# London Luton Airport Expansion

## **8.11 Statement of Common Ground between London Luton Airport Limited and National Highways**

**8.11 STATEMENT OF COMMON GROUND BETWEEN LONDON  
LUTON AIRPORT LIMITED (TRADING AS LUTON RISING) AND  
NATIONAL HIGHWAYS**

<b>Deadline:</b>	Deadline 2
<b>Planning Inspectorate Scheme Reference:</b>	TR020001
<b>Document Reference:</b>	TR020001/APP/8.11
<b>Author:</b>	Luton Rising

16.5m Articulated HGV  
Swept Paths At Junction 10  
of the M1 with 2039  
27mppa Mitigation Scheme  
Scale 1:1000 at A1  
Drawing Number - SK053

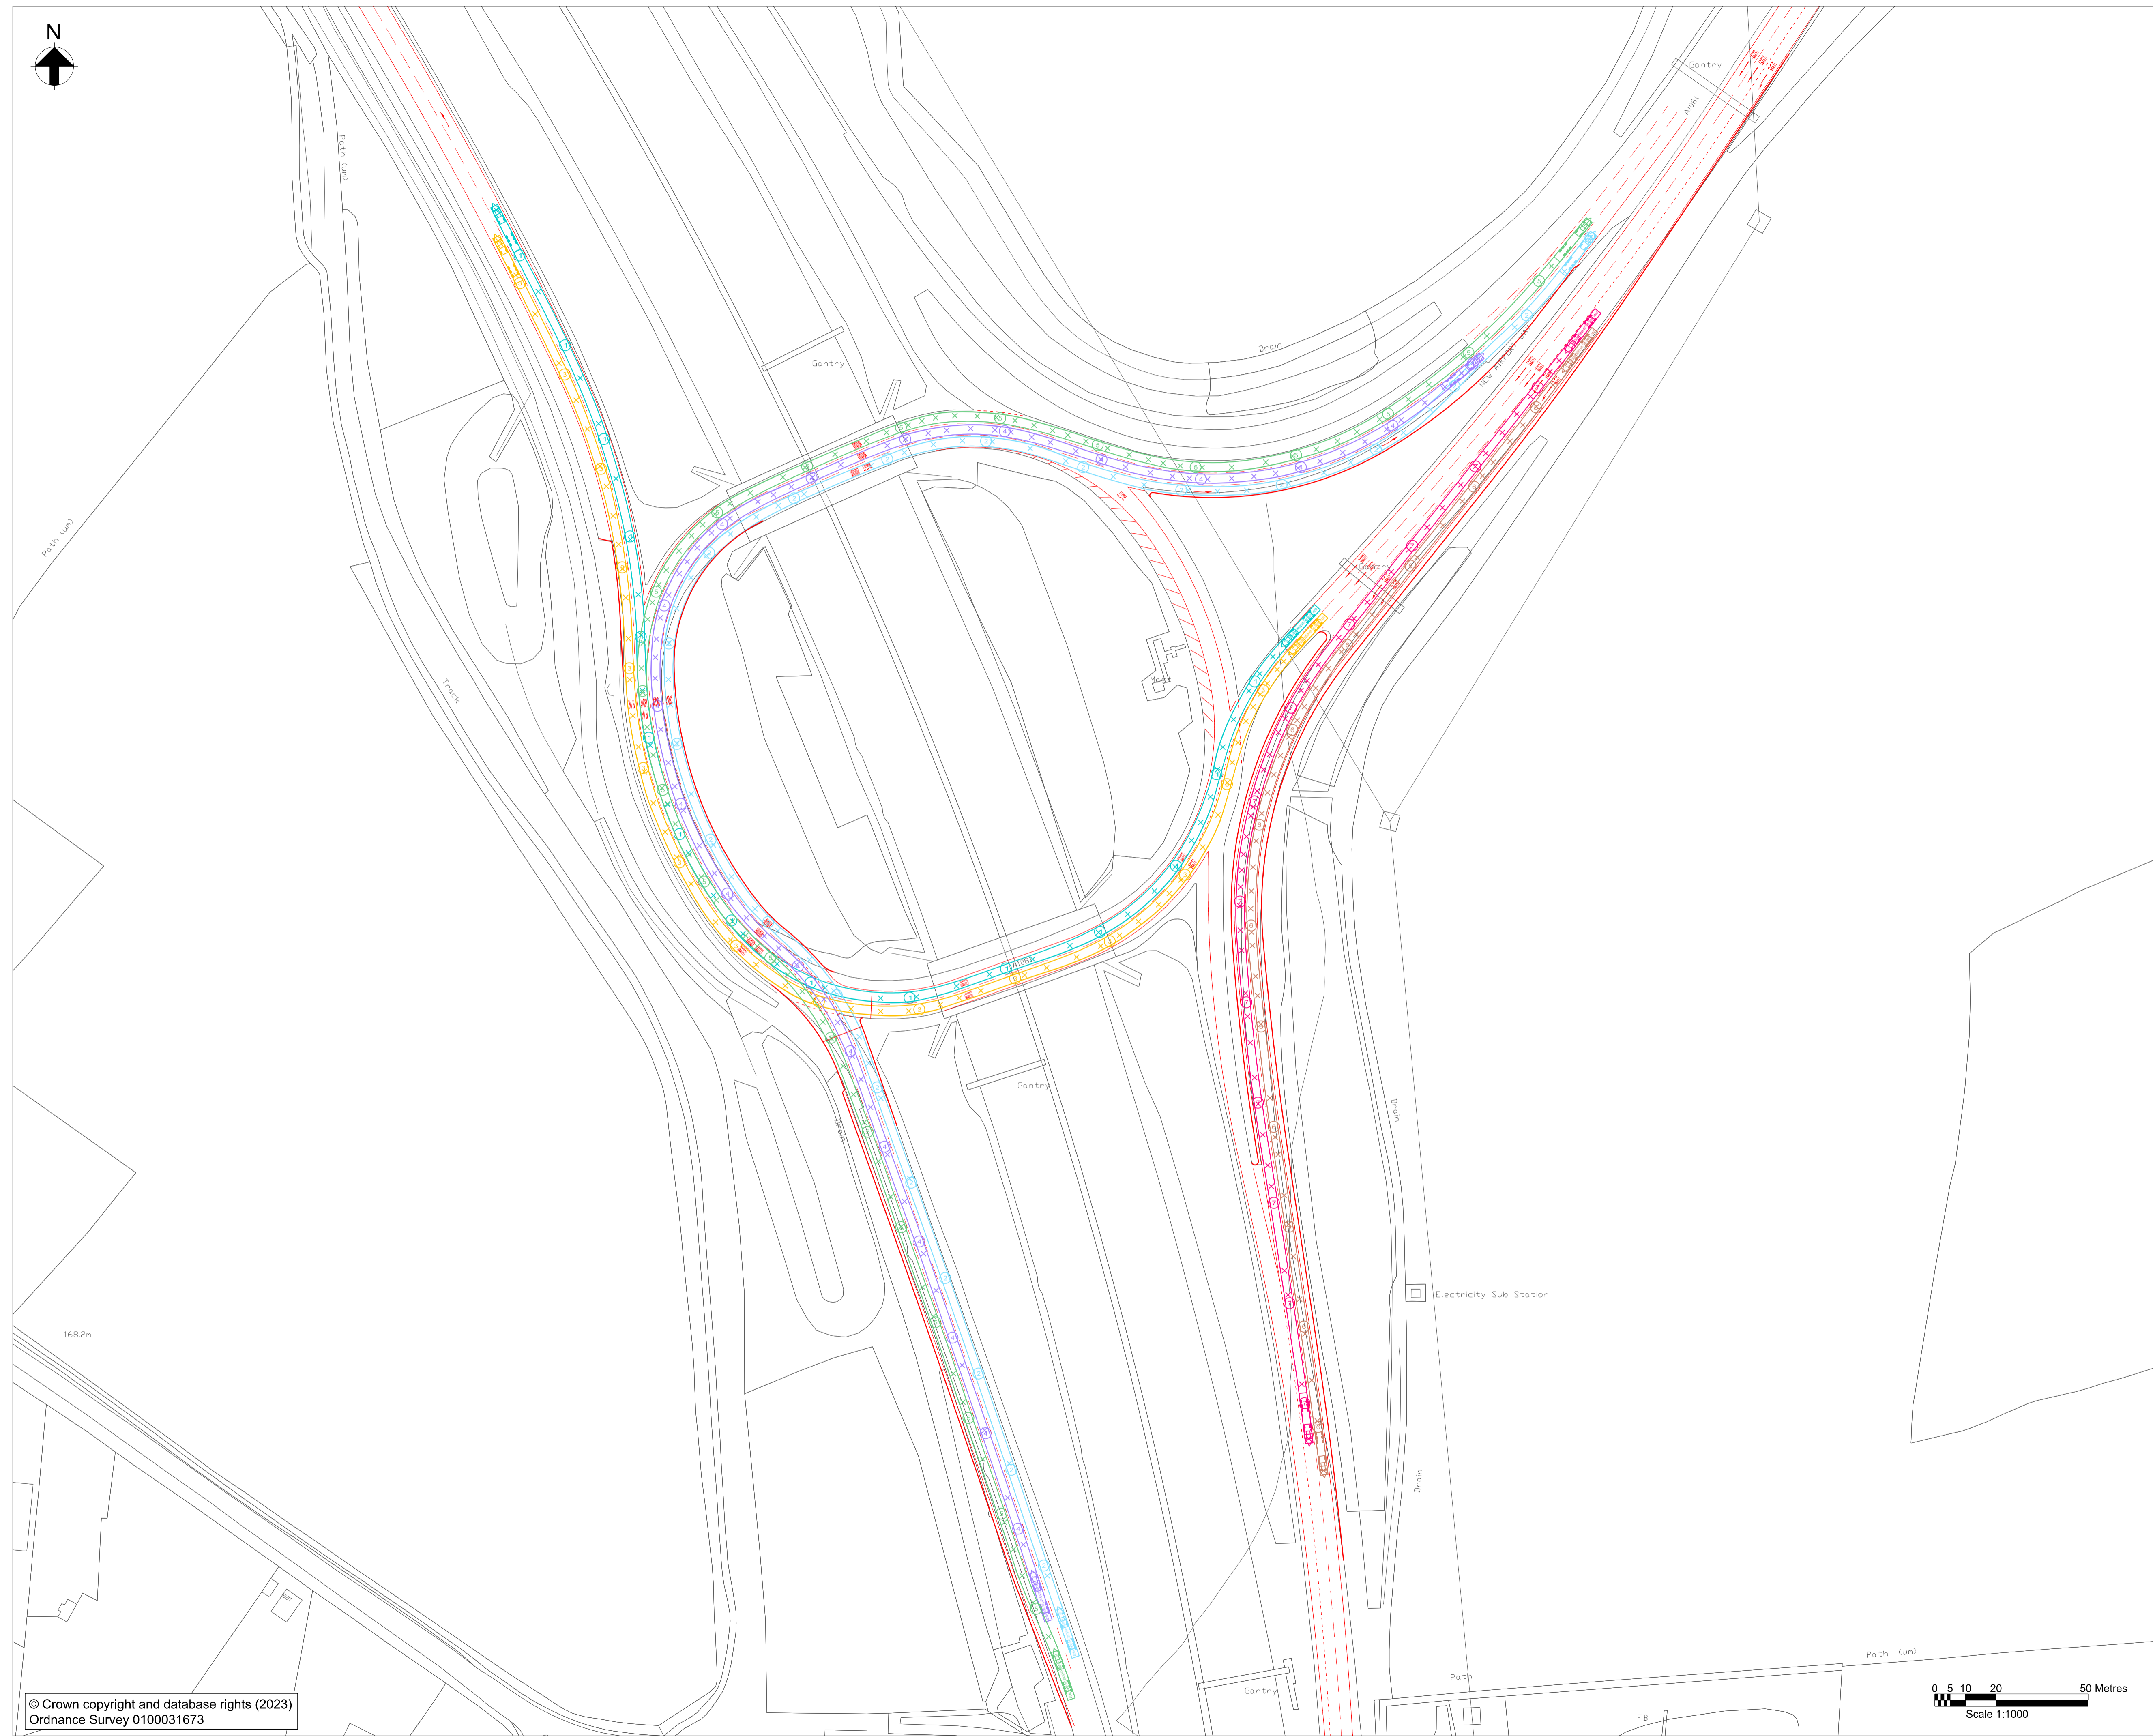
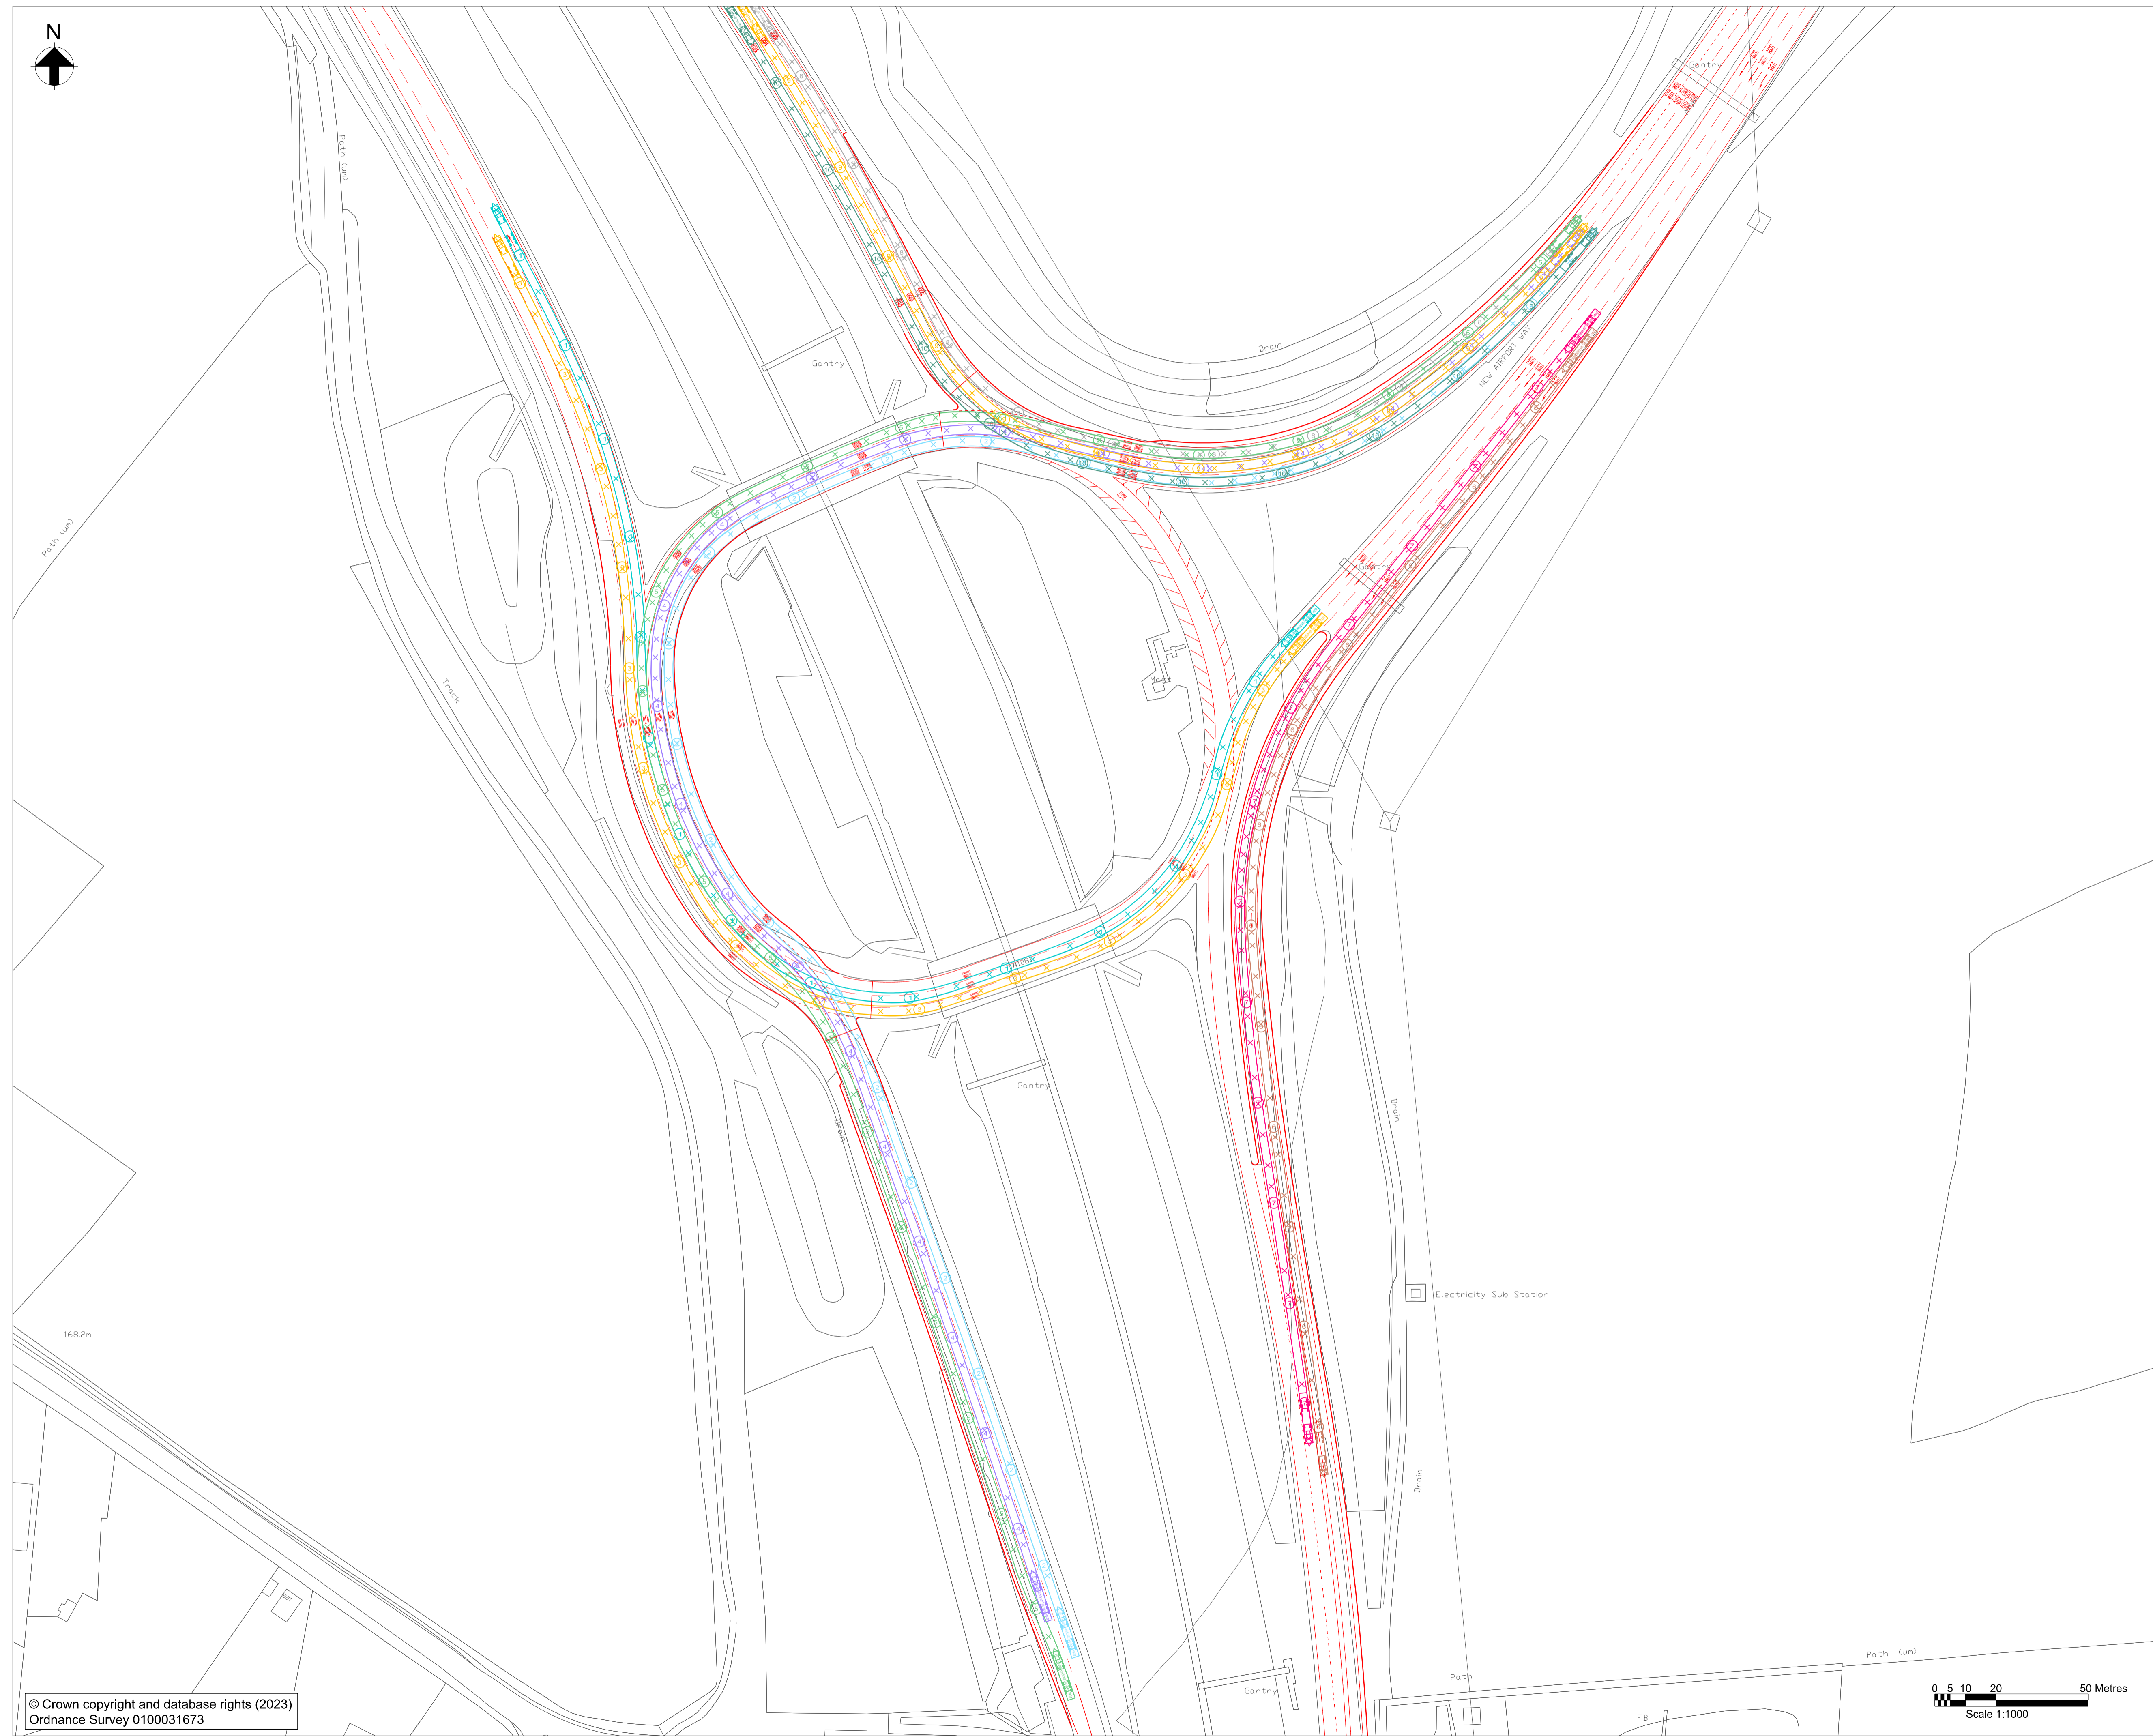
3.2.5	Junction 10 enhancements – lane widths	It is important that lane widths within the curved section of the circulatory are able to accommodate HGV swept paths without cross-lane encroachment.	<p>Tests have been undertaken to ensure that the proposed circulatory lane widths are able to accommodate side-by-side HGV movements and further information can be provided to National Highways to confirm this.</p> <p>Where appropriate and/or necessary, the Applicant will provide an updated response at Deadline 3.</p>	Ongoing
